Consultation Response from KC Waste Strategy (Refuse & Cleansing)		
PA no. & address: 2021/91914 rear of, 28, Northorpe Lane, Northorpe, Mirfield, WF14 0QN		
Proposal: Demolition of one dwelling, erection of 45 dwellings with access and associated infrastructure		
Date Responded: 04/06/2021	Responding Officer: Carol Oakden	Responding Ref: WPN-21-010

Drawing **Proposed Site Layout**

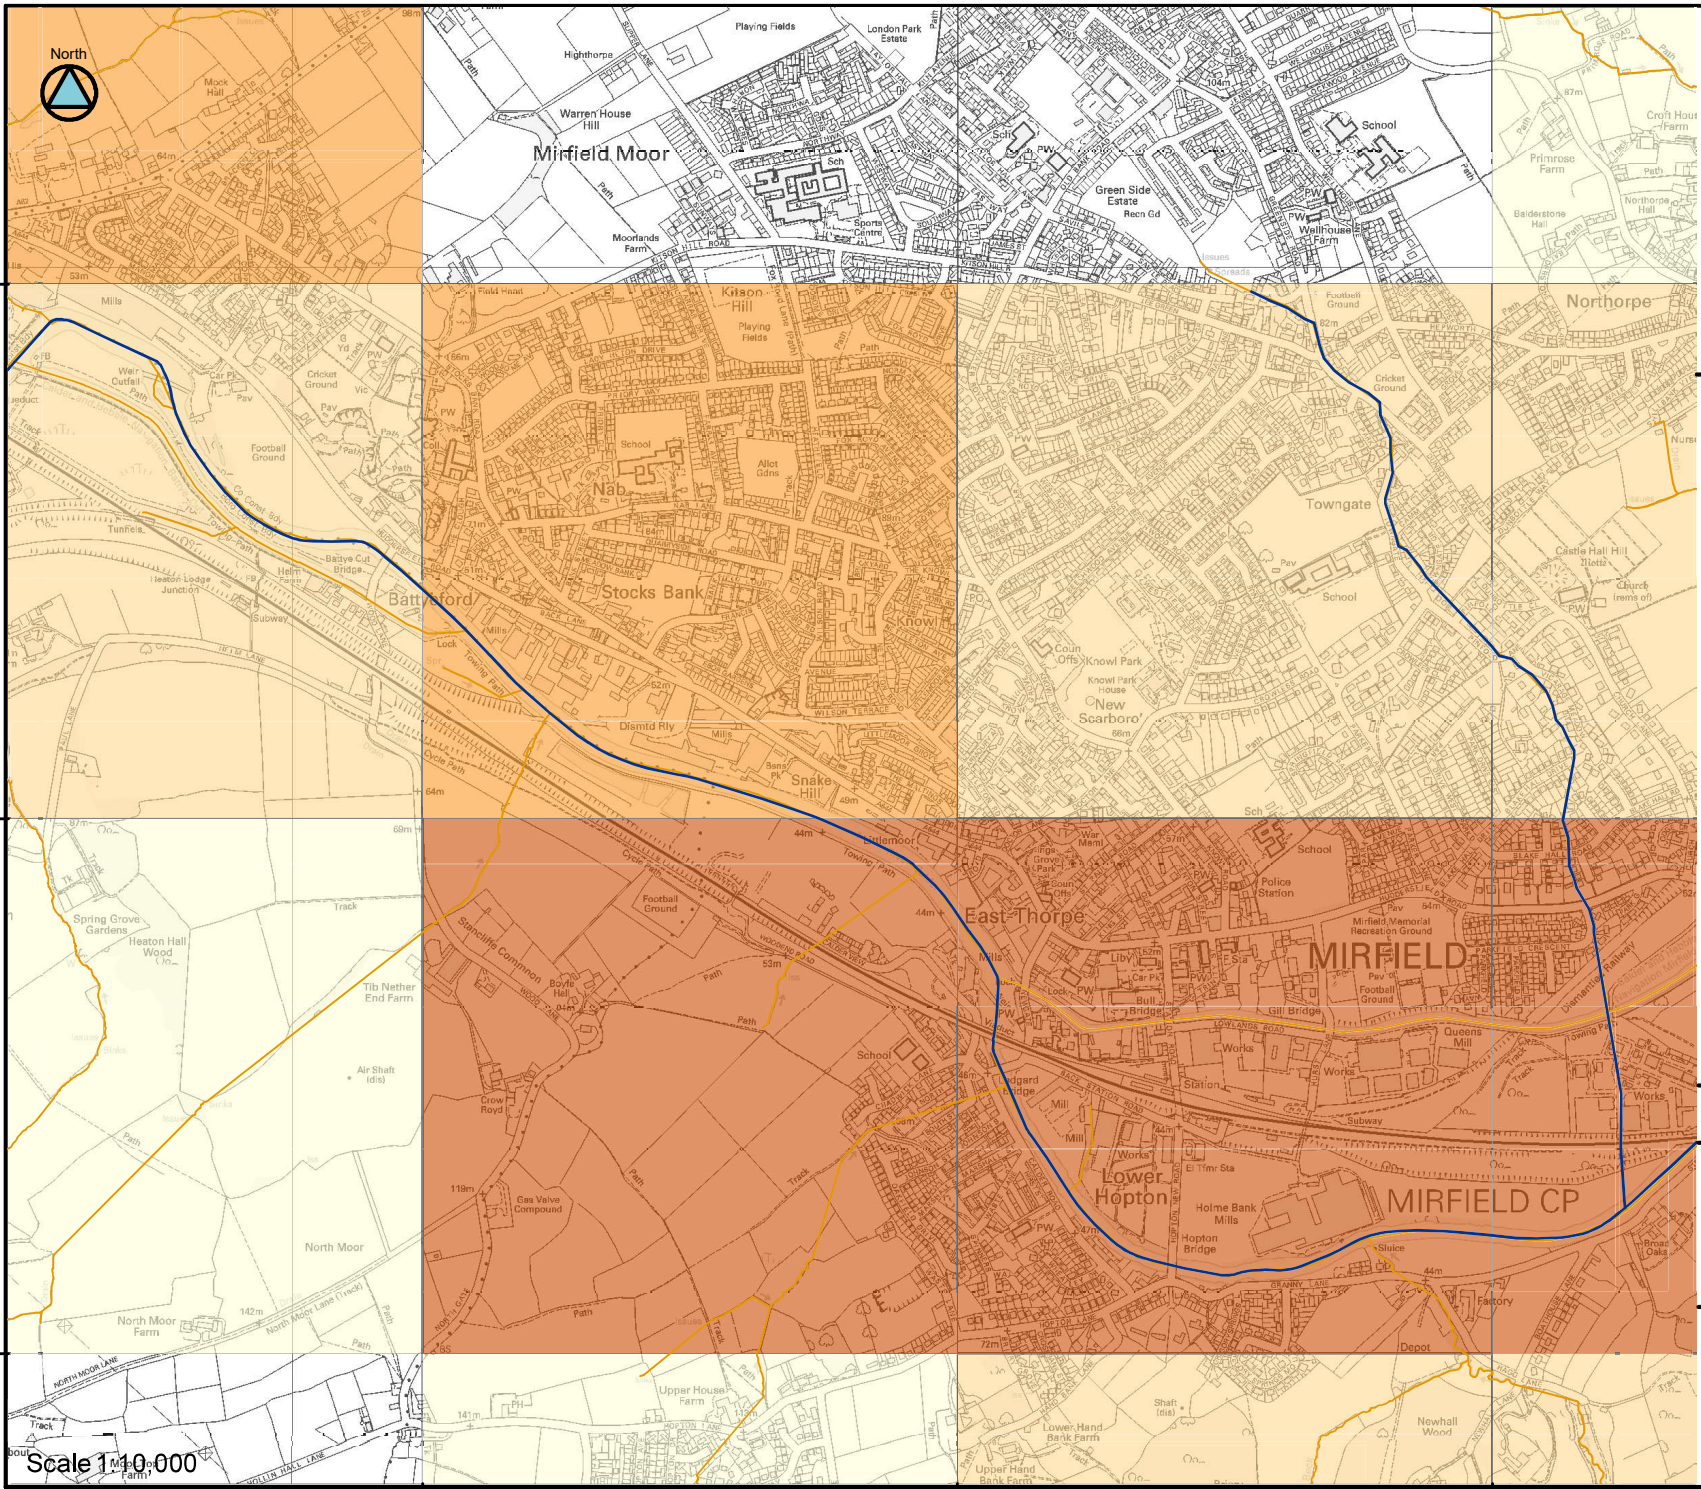
- Layout drawing P002-RevC shows each plot with space to the rear for the storage of 3 x standard wheeled bins, with private gated access, which is in accordance with our guidelines. Plots 21 and 22 are mid-terraced and have convoluted rear access which will discourage the storage of bins to the rear. This is exacerbated by the use of 1800mm solid timber fencing along the ginnel access routes, making these somewhat unfriendly to use. Suitable bin enclosures to the front of these plots would be preferred. These need to be secure to help prevent unauthorised use/theft/damage to bins and be designed to help screen the impact of bins in the street scene whilst being accessible for residents to use.

- Plots 36-38 are on a private shared drive and require a communal bin presentation point located close to the adopted highway. This must be a level, hard-surfaced space big enough for at least 3 bins and located so that bins waiting to be collected do not cause obstruction.

- Suitable site access and manoeuvrability space for an RCV is vital to the Council's ability to discharge its obligation to collect waste from domestic properties. This obligation will exist in perpetuity on any residential development and as such will be a critical consideration in the layout of the site if approval is granted. A swept path drawing is provided as part of the transport assessment, but this uses an incorrect vehicle specification (refer to the Kirklees Highway Design Guide SPD for full details of the required dimensions).
- Parked cars are a perpetual problem for RCV access and as such it is important to account for potential parking spaces, even where these are undefined, in the swept path analysis – this has not been done. There are no visitor parking spaces allocated on the layout which will exacerbate the instance of on-street parking,

potentially blocking access for RCVs and other large vehicles. Parking in the turning head could become a particular problem and measures to prevent this should be explored. If this turning head is blocked, a long reverse manoeuvre will be necessary to enable waste collection to take place and this is contrary to our access requirements. This would also impact on the access for Yorkshire Water tankers visiting the pumping station.
